9 March 2009

**Re: Site 3, Australia Avenue, Sydney Olympic Park – MAJOR PROJECT No. 06_0127
Section 75W amendments**

EQUINOX - 22nd MARCH/SEPTEMBER_3pm

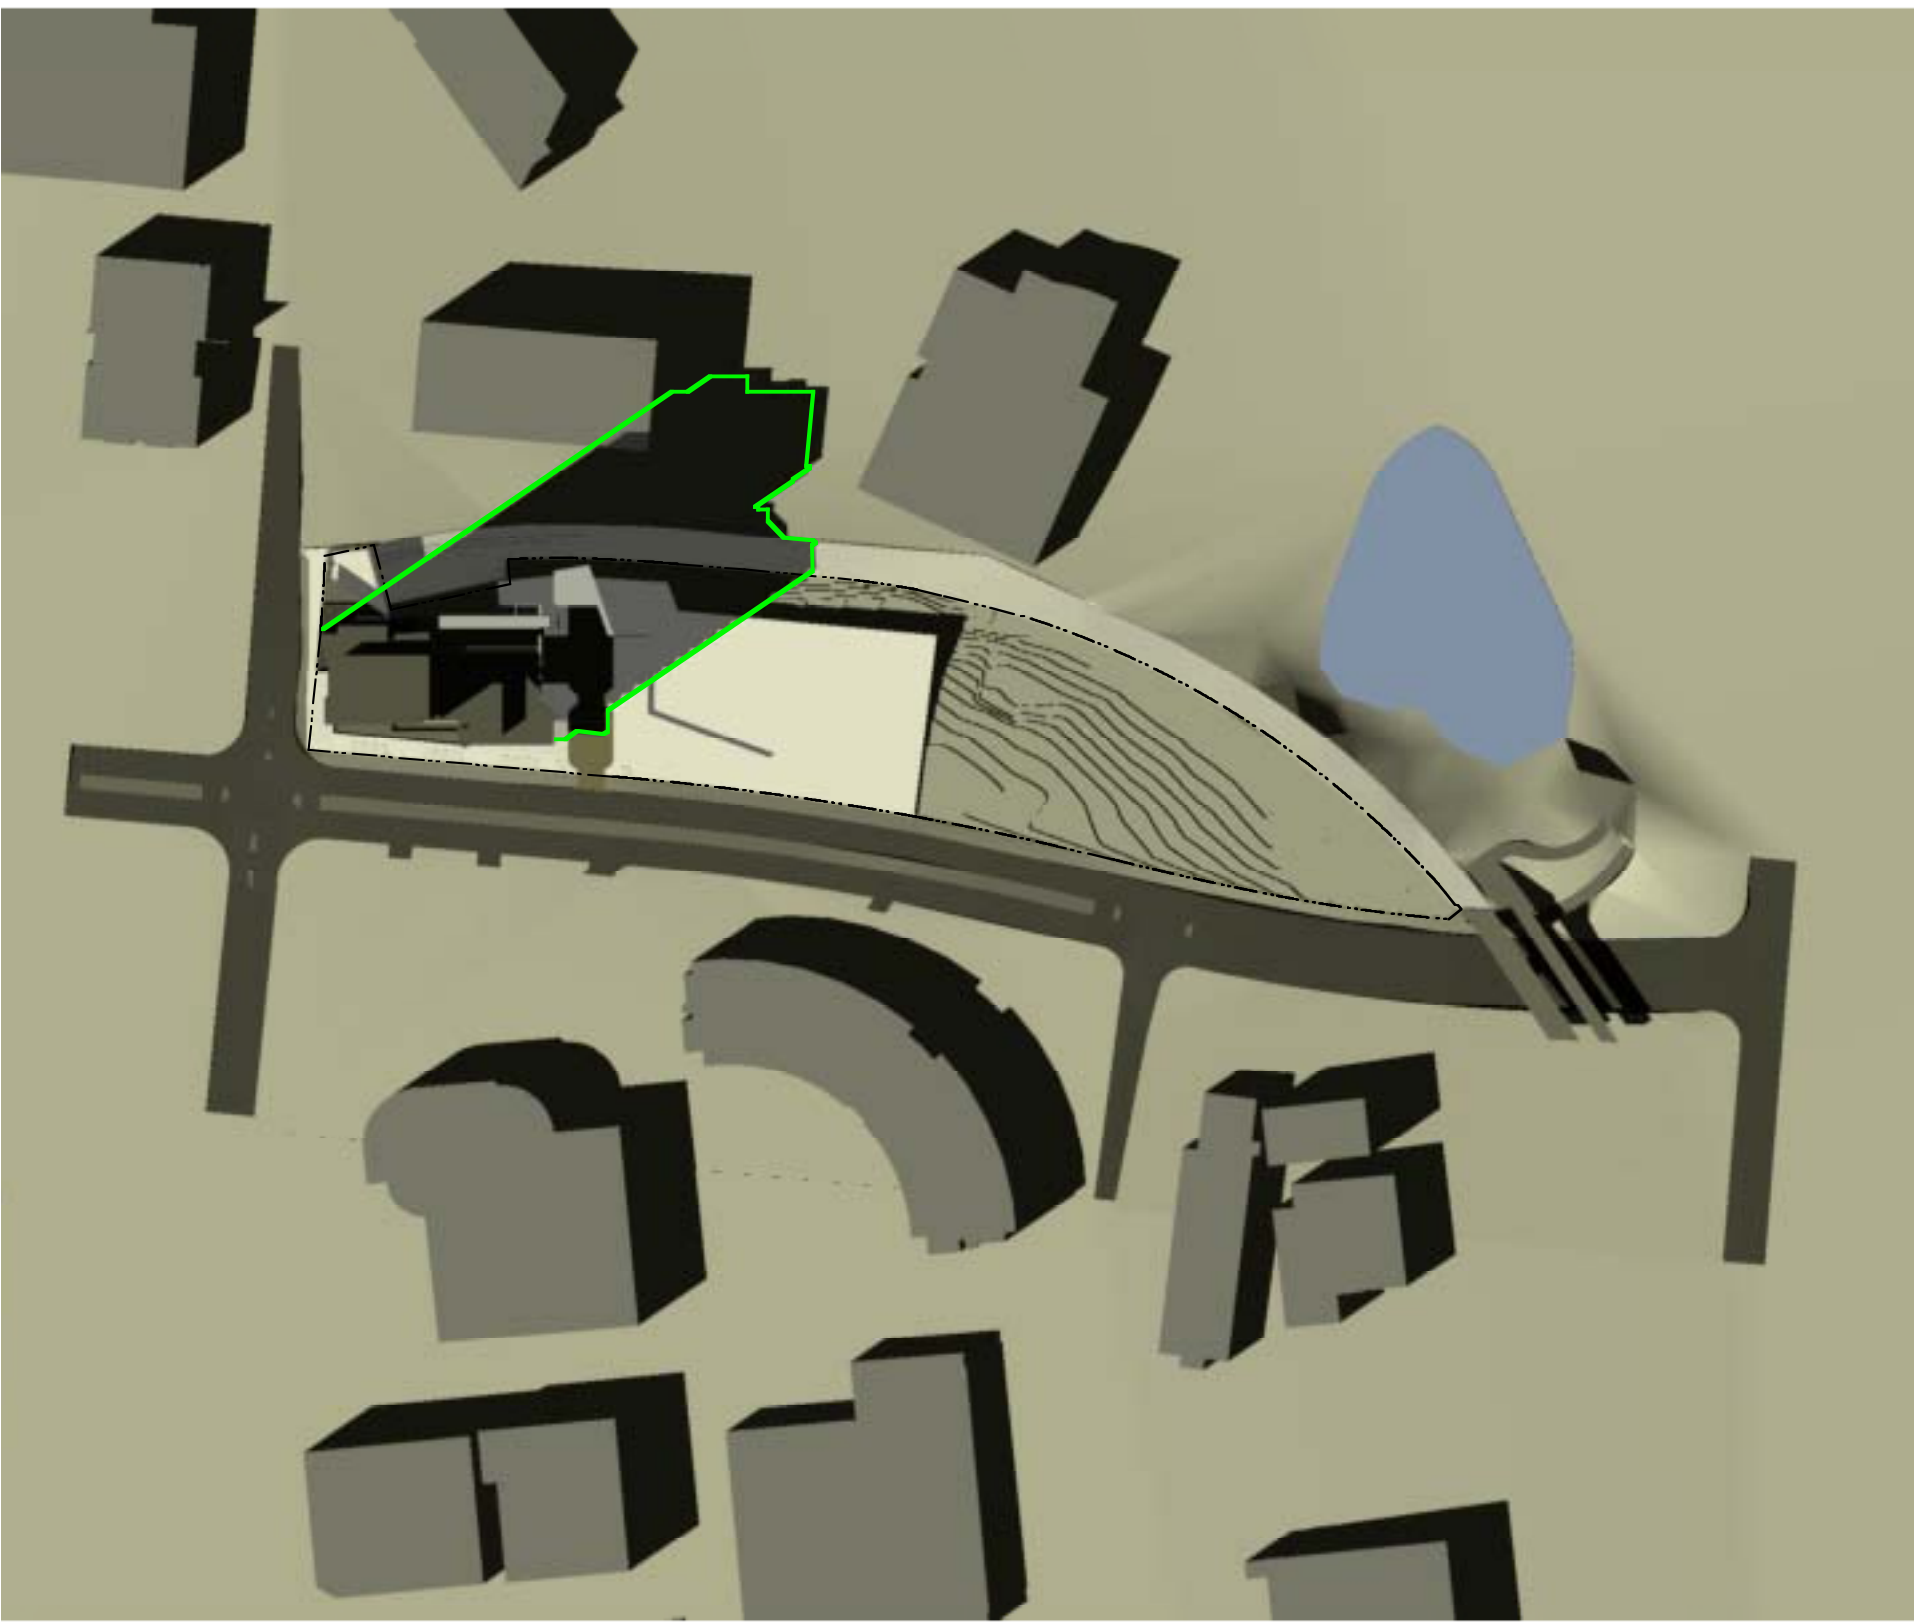
Overall this equates to Tower A part of the building being 2.6 m higher and Tower B part 1.7 m higher. In relation to the original approximate building heights of 80.65 m (A) and 55.6 m (B) the increase is minor and does not cause any significant loss of amenity to its surroundings. On 22 June the shadow of Tower A would increase by only 4.1 m at 12pm and 7.8 m longer at 9am/ 3pm. Tower B's shadow would increase by only 2.7 m at 12pm and 5.1 m at 9am/ 3pm on the same date.
